Application No: BN/18/20/PL
Site Address: Former Brooks Nursery Eastergate
Description of works: Variation of condition 15 imposed under EG/29/13/ relating to condition 15 - to change the foul drainage scheme from Sewage Treatment Plant to Pumping Station with associated drainage works.

Thank you for your internet representation made on 24th May 2020 which has been recorded as an objection with the comments as follows:

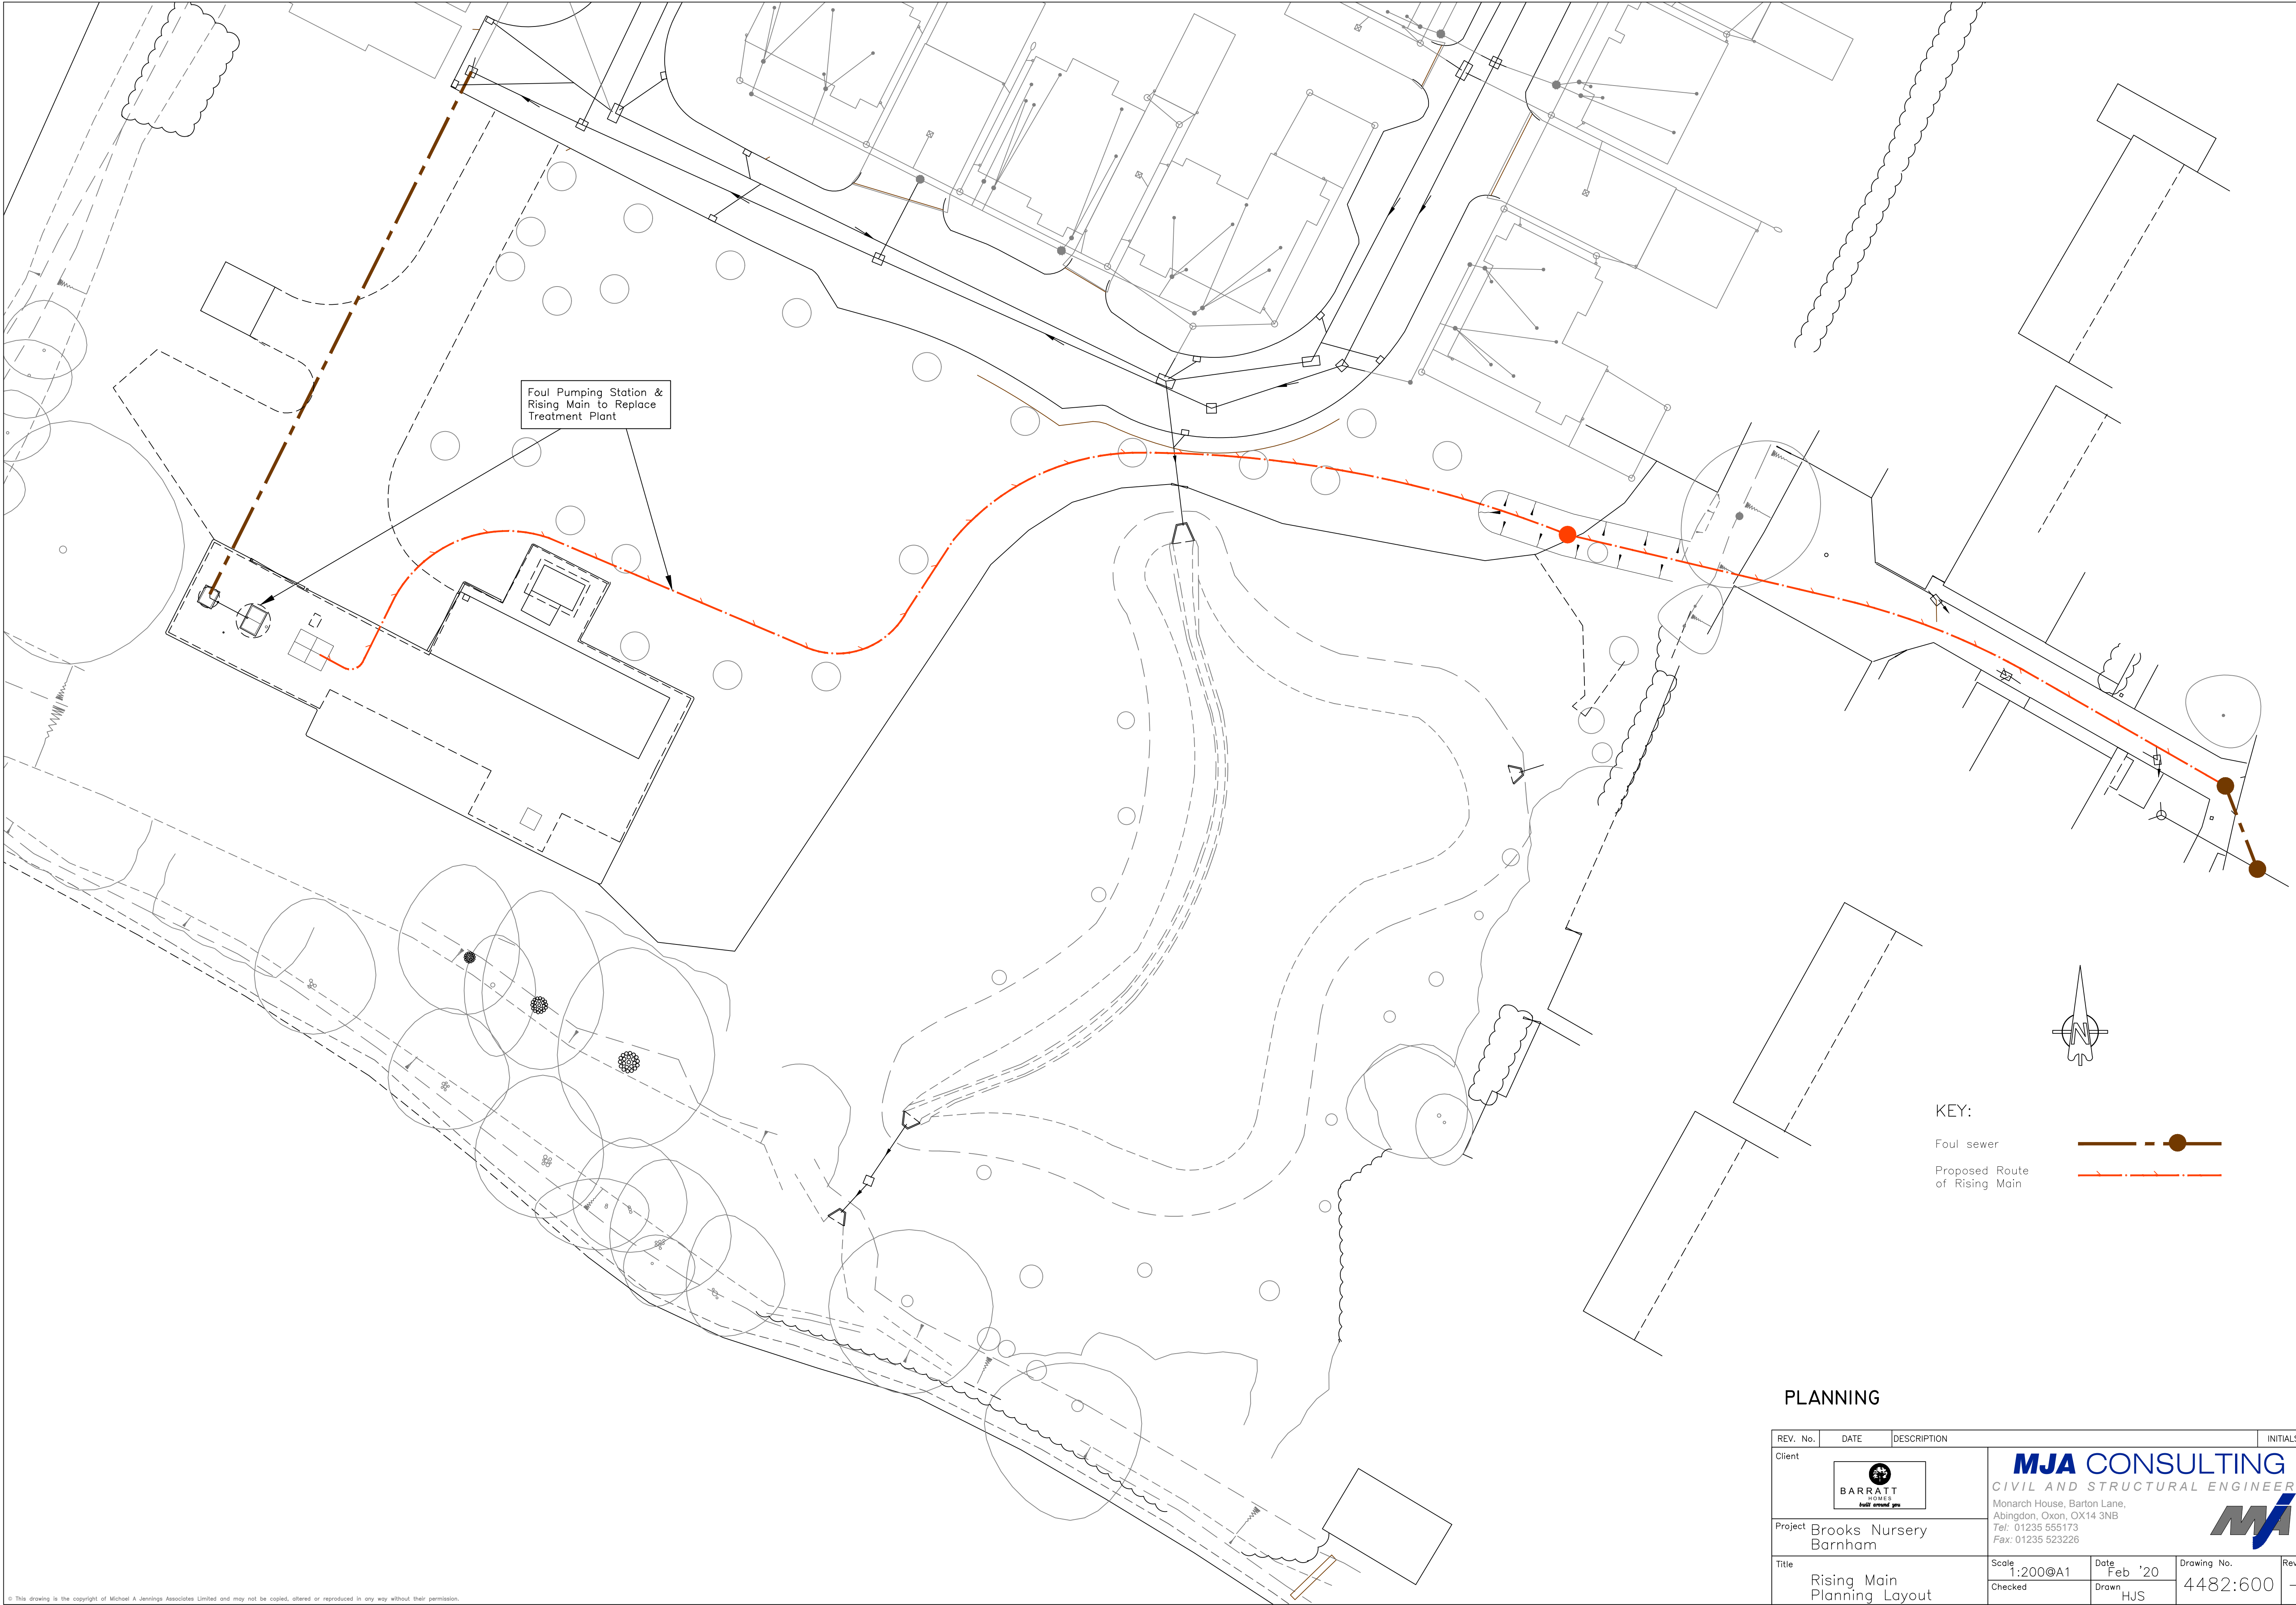
2. The proposed connection of a 200mm dia pumped rising main to an historic 150mm gravity main is technically questionable and not in keeping with accepted good drainage design practice. Irrespective of any submitted drainage calculations purporting to demonstrate the adequacy of such an arrangement, basic engineering principles suggest that the arrangement would not provide an acceptable solution and, to any drainage engineer, is intuitively flawed.
